MORGAN AND MORECAMBE OFFSHORE WIND FARMS: TRANSMISSION ASSETS

Applicants' Response to Examining Authority's Written Questions (ExQ1)

Deadline: Deadline 3
Application Reference: EN020028

7 July 2025

Figure 1 : Indicative Cross Section of the River Ribble Crossing (refer to the Onshore Works Plans (APP-154))

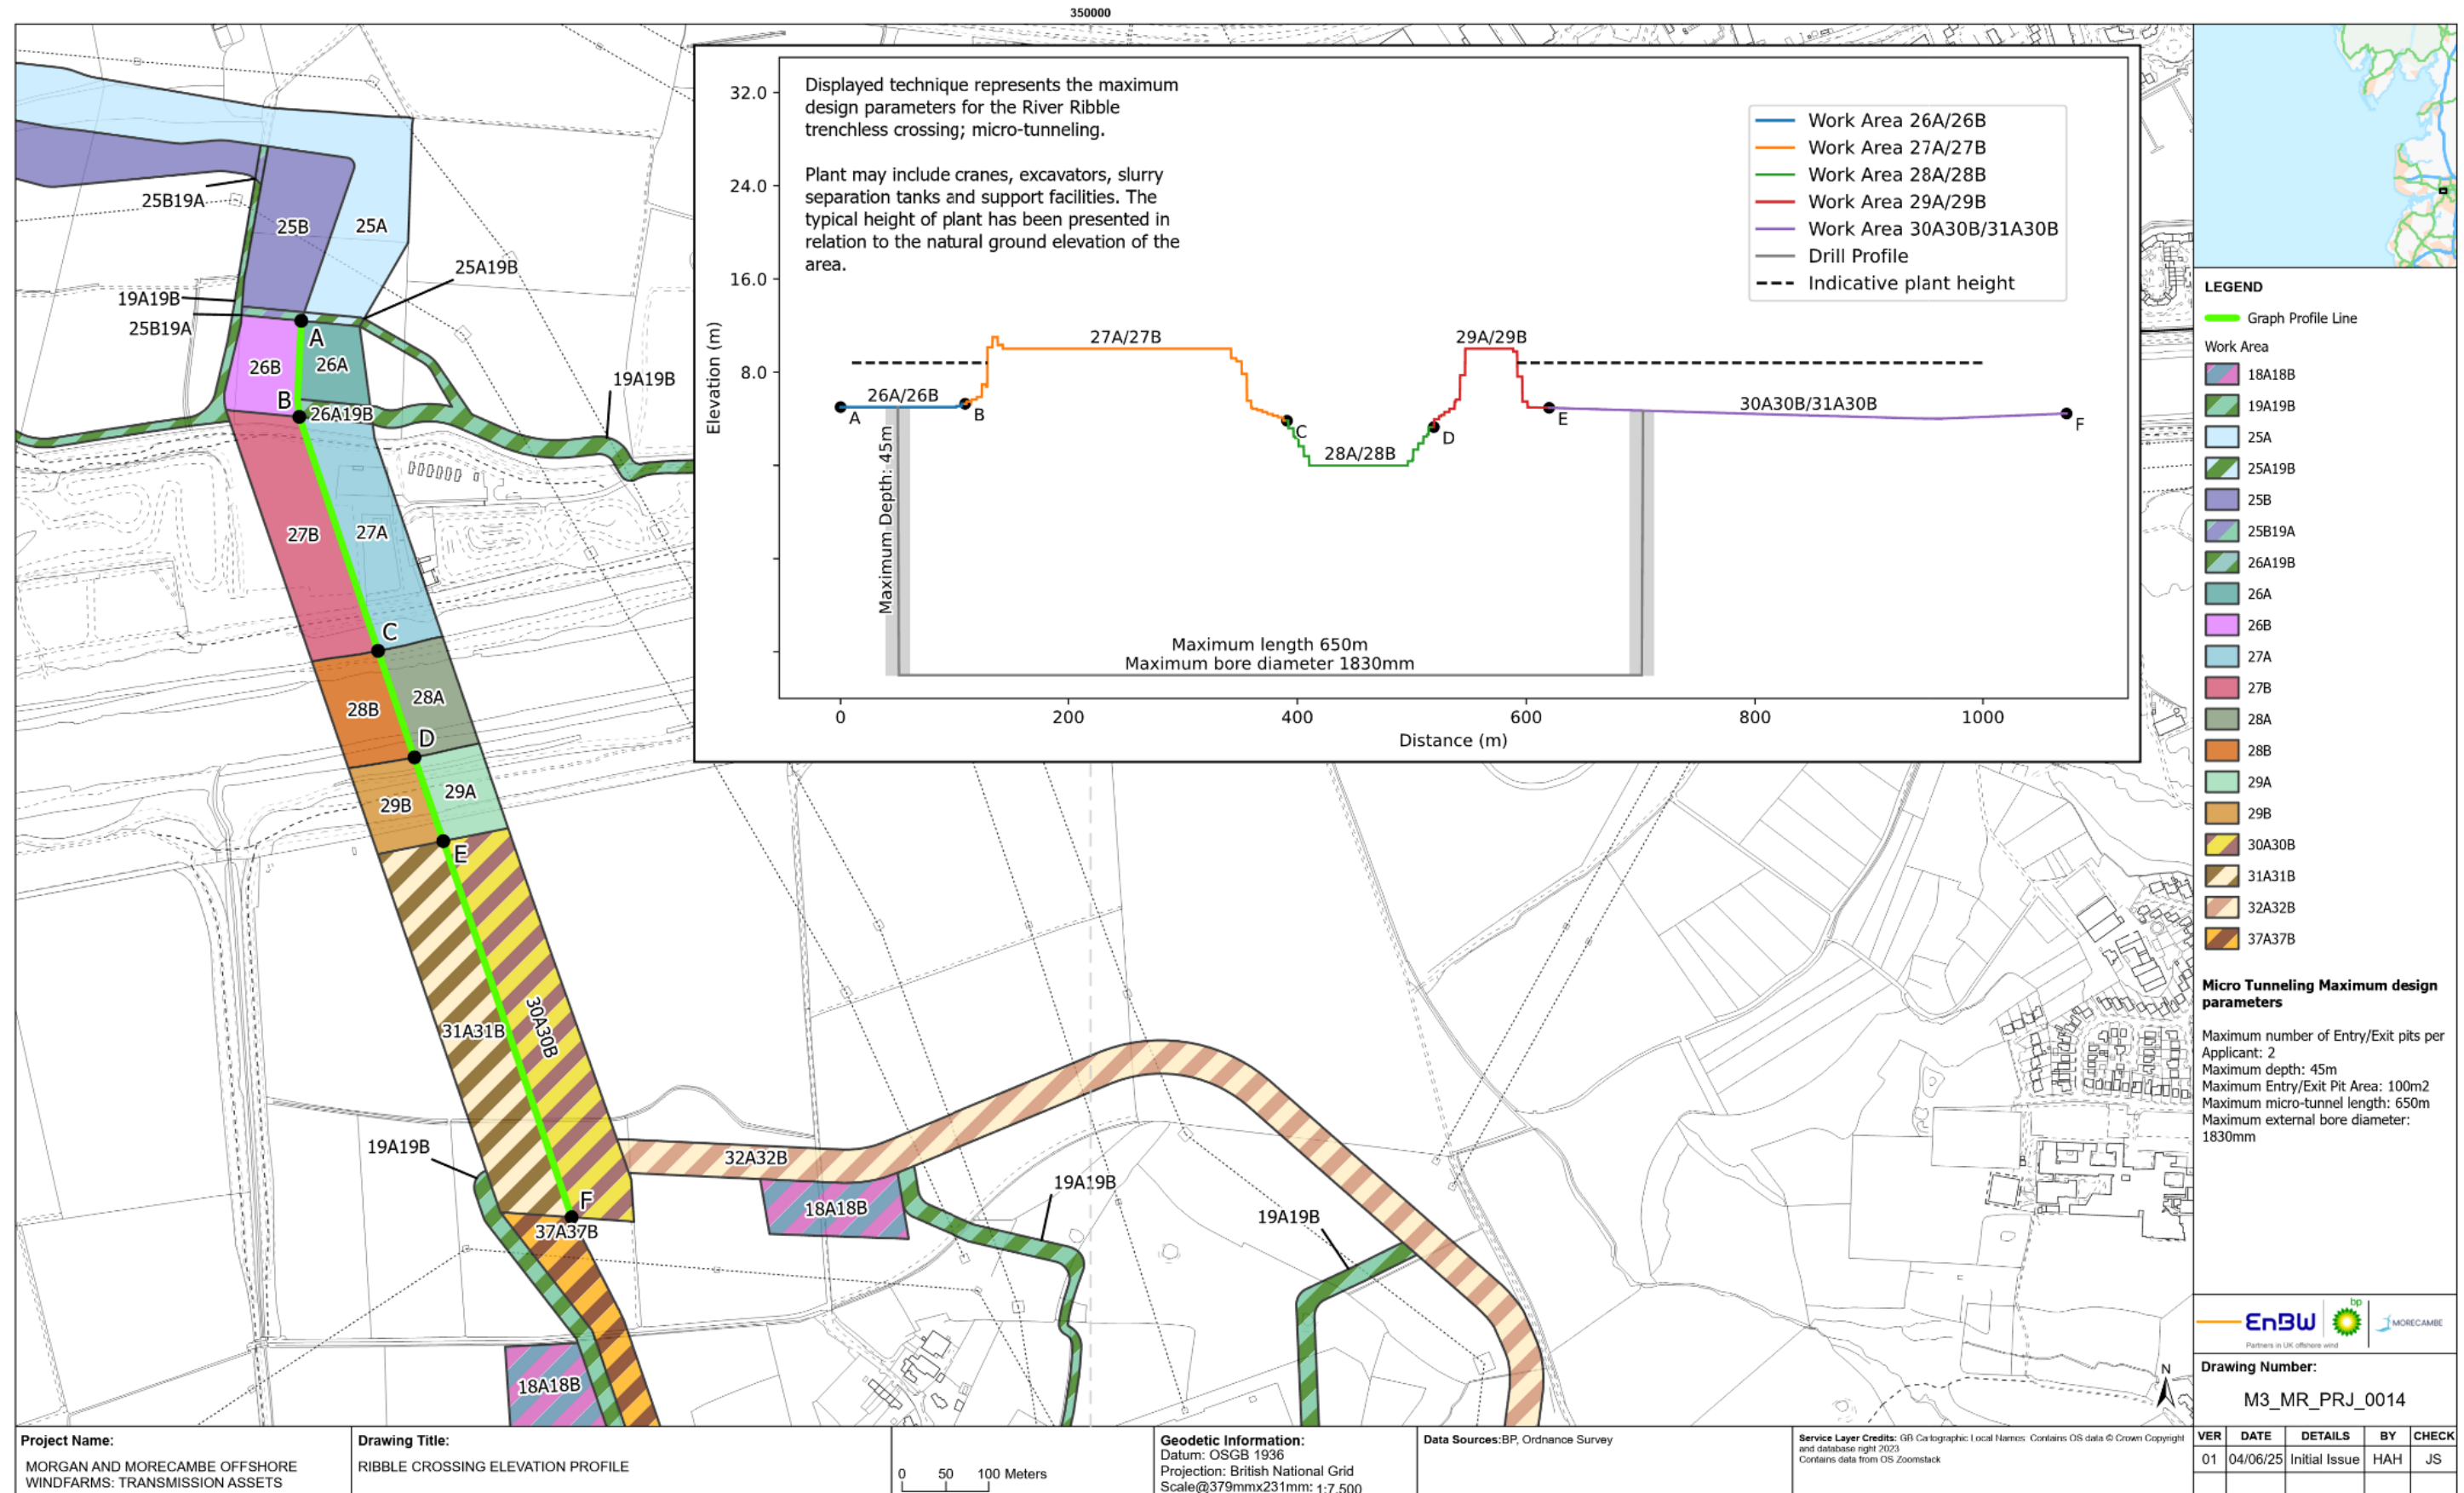
Reference	Question To	ExQ1	Applicants' response
1.1 Scope of the development and general matters			
Q1.1.1	The applicants	<p>River Ribble crossing</p> <p>The written representation from South Ribble Borough Council [REP1-097] raises concerns at the lack of plans to clearly show how works to cross the River Ribble will be conducted.</p> <p>For each of the two potential trenchless installation techniques (micro-tunnelling and direct pipe) described in the Project Description [REP2-008] provide indicative drawings showing (a) the layout of relevant construction works (including compounds) and (b) a full cross-section showing the full extent of the proposed works taking</p>	The Applicants provided indicative drawings for each of the two potential trenchless installation techniques in Annex 3.1 to Applicants response to ExQ1: Q1.1.1 – River Ribble Crossing (S_D3_3.1).
